Comment Response

Project Name: Septimus Community Association

Response To: SHL22-019 SUB3 Review Letter; 770X SE 58th ST, Mercer Island, WA 98040

**SHEET  
 A2.0**

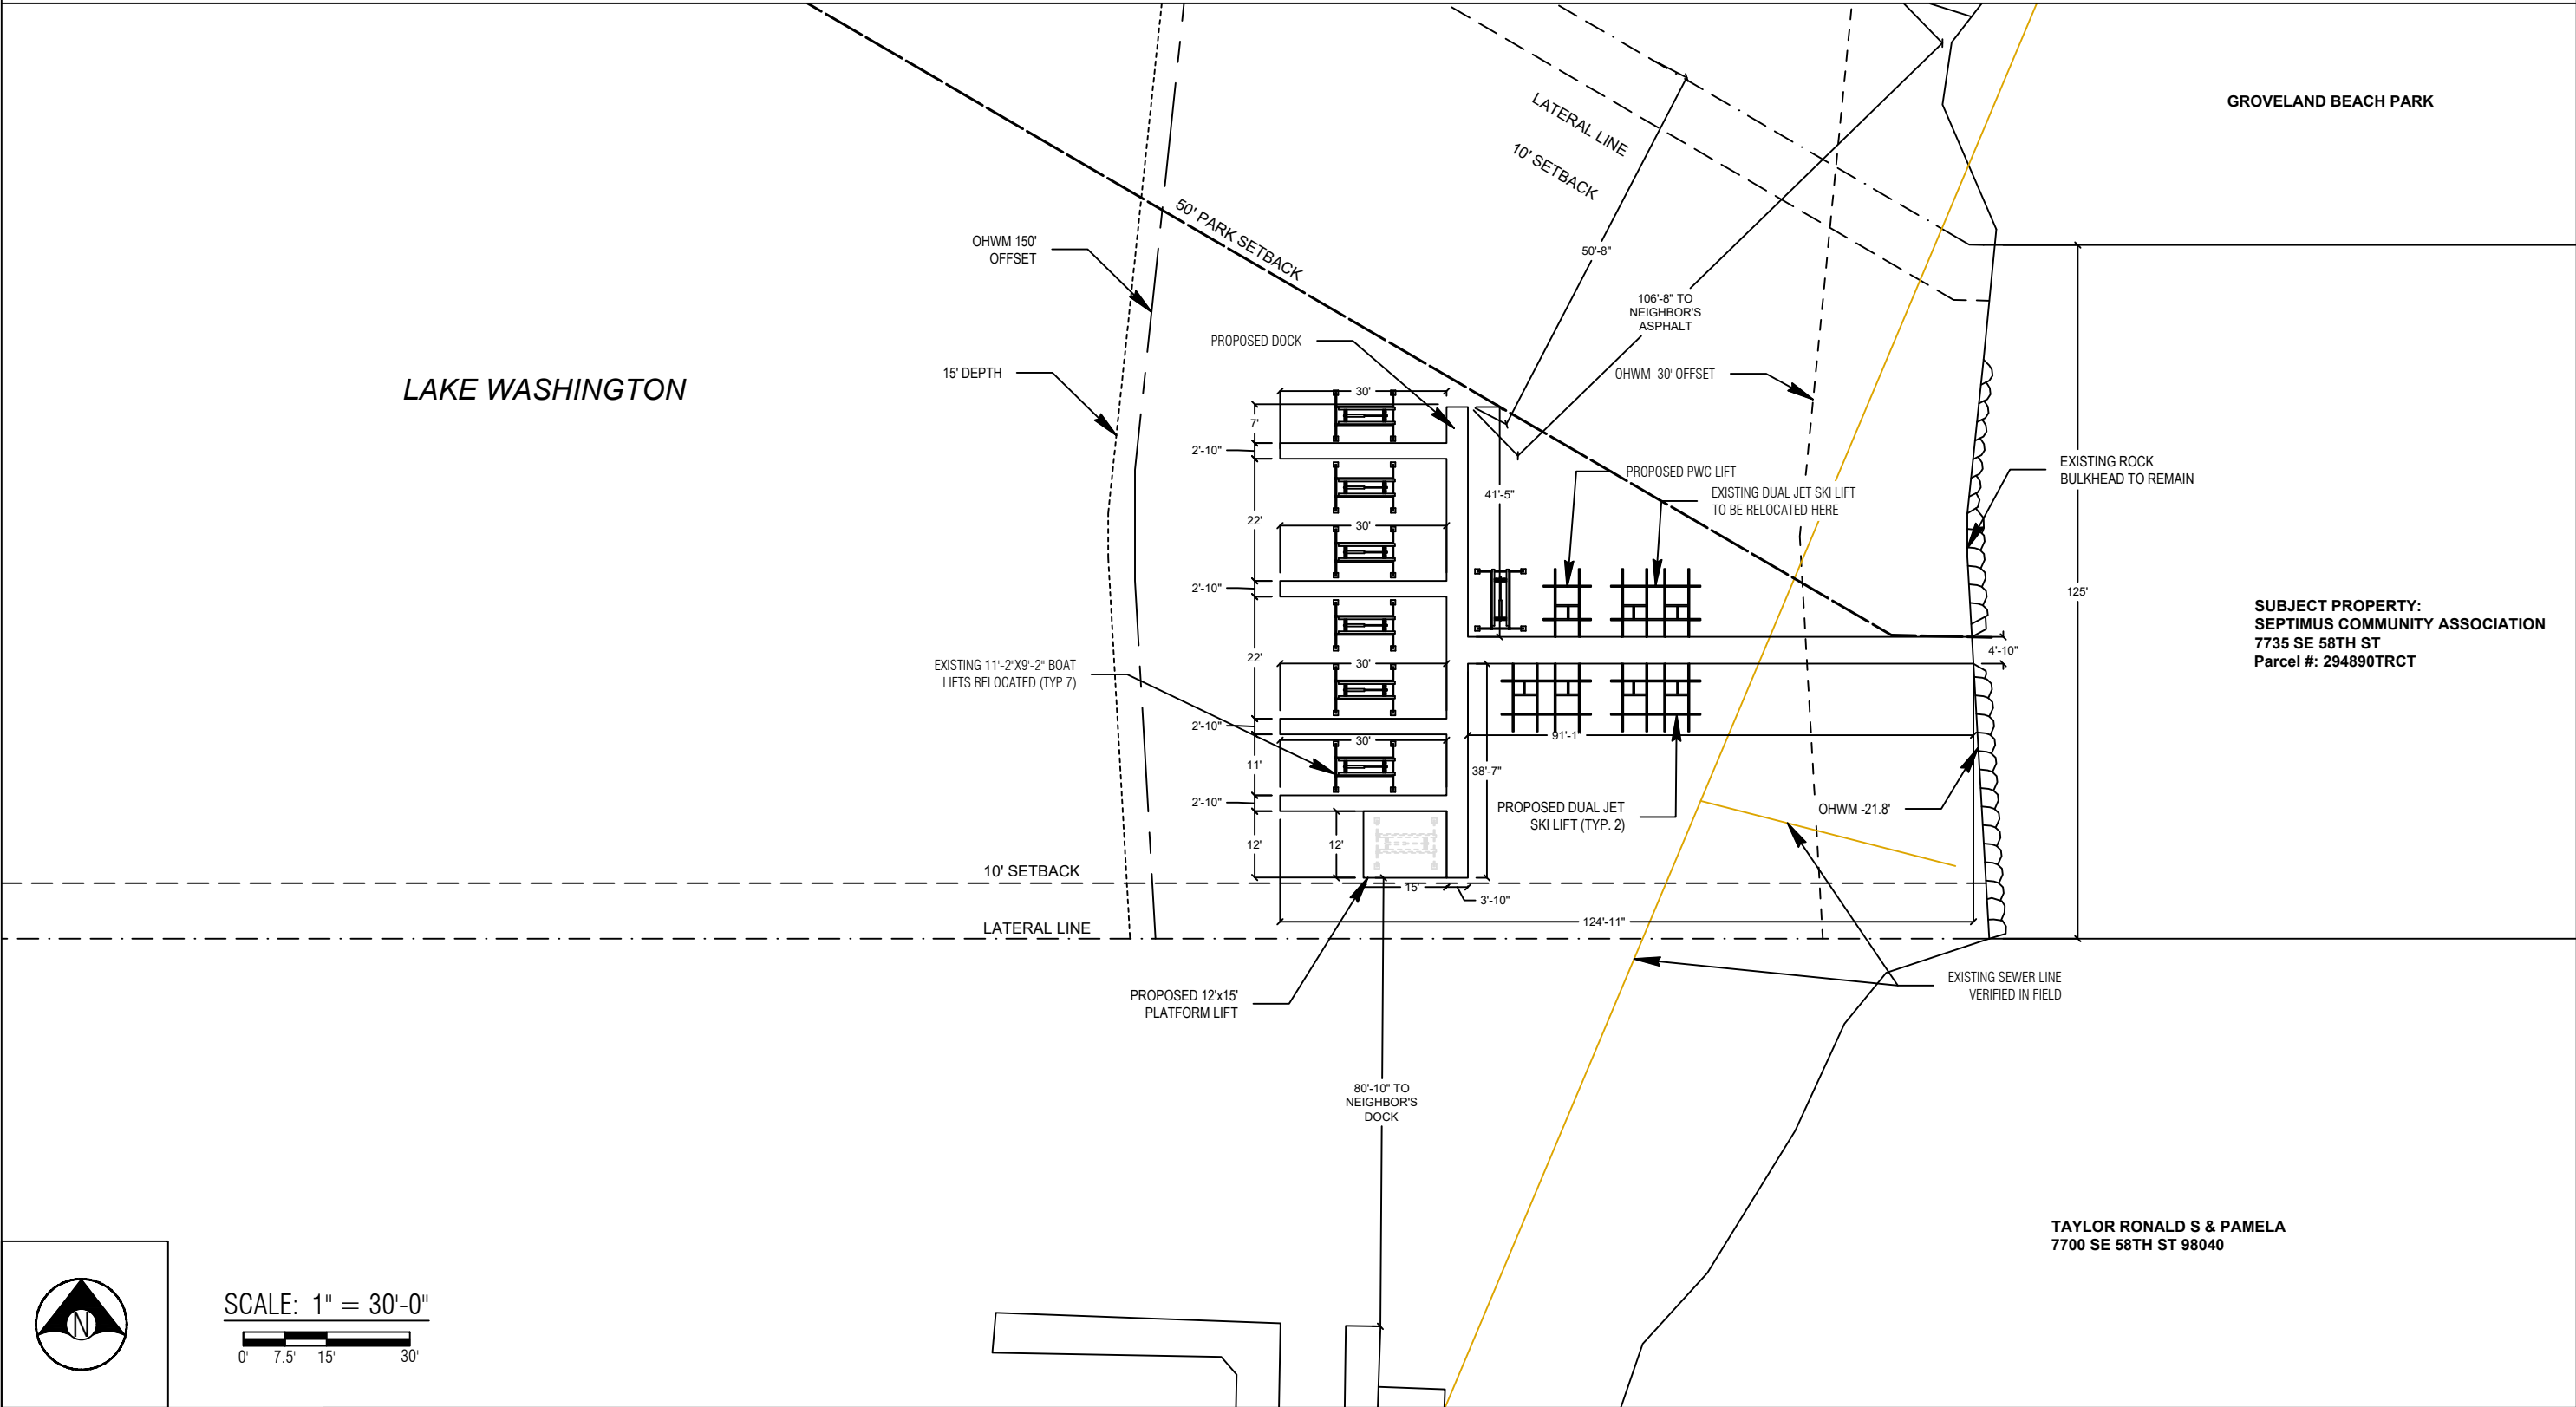
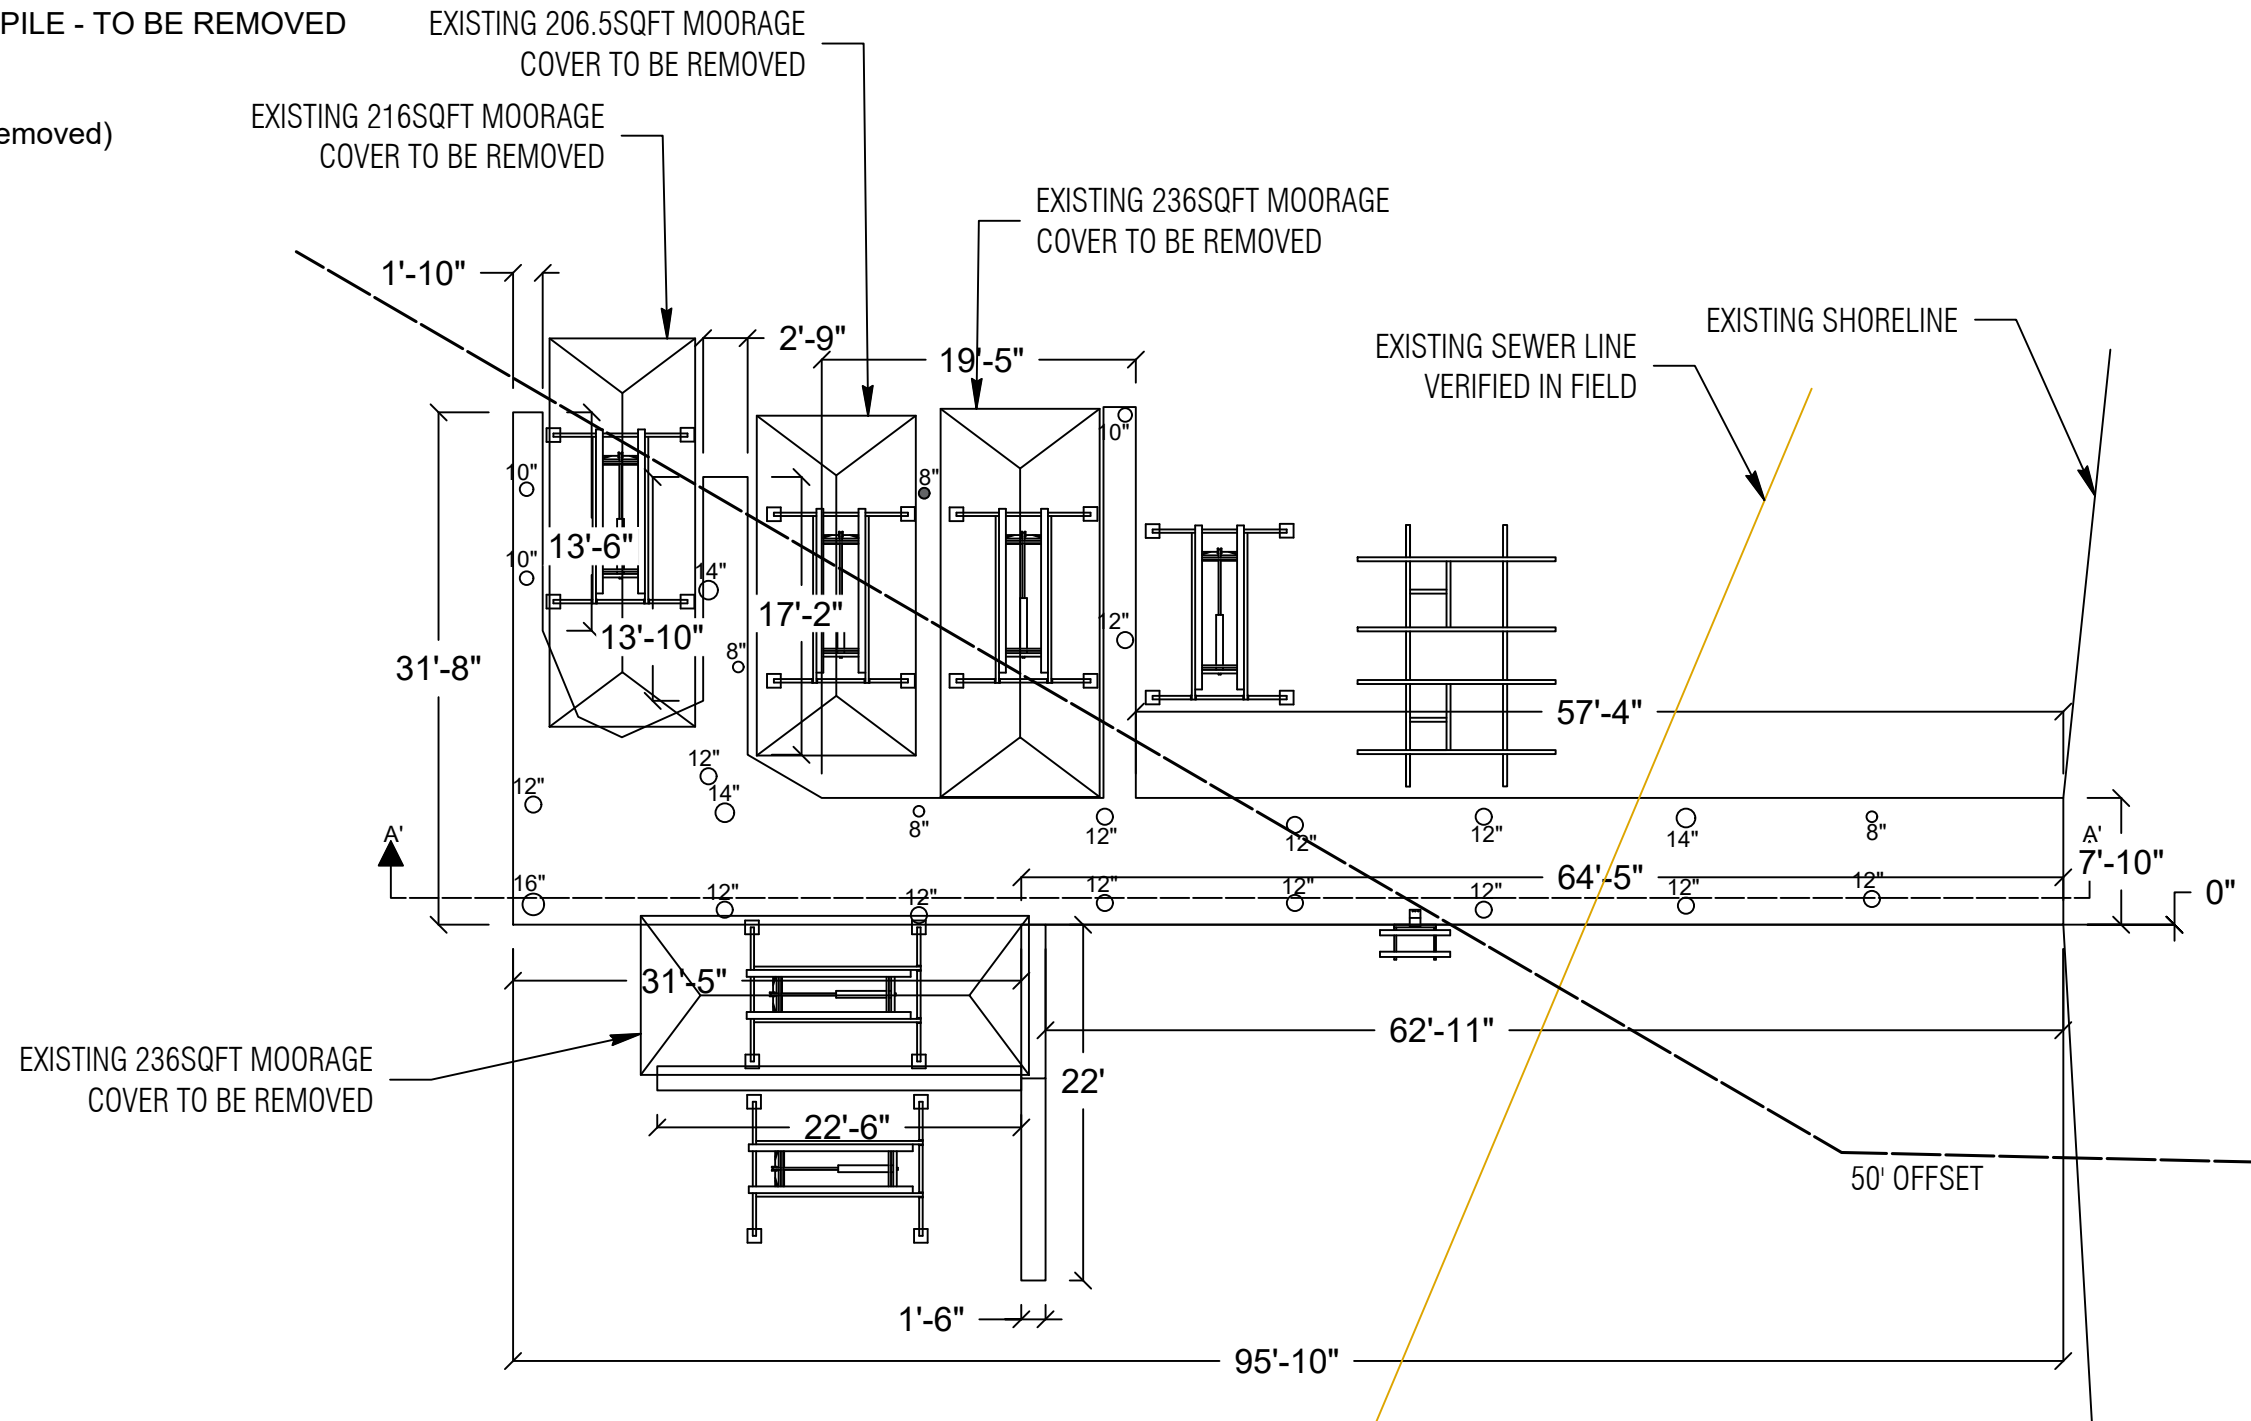
1. Provide documentation demonstrating compliance with MICC 19.13.050(D) Table D for Requirements for Moorage Facilities and Development Located Waterward from the OHWM (continued) - Minimum Water Frontage for Docks:

a. Semi-private recreational tracts

Response: Please see sheets A2.0 and A3.0 showing the measurement of the water frontage of this parcel to be 125' which is over the 70' minimum needed per the code.
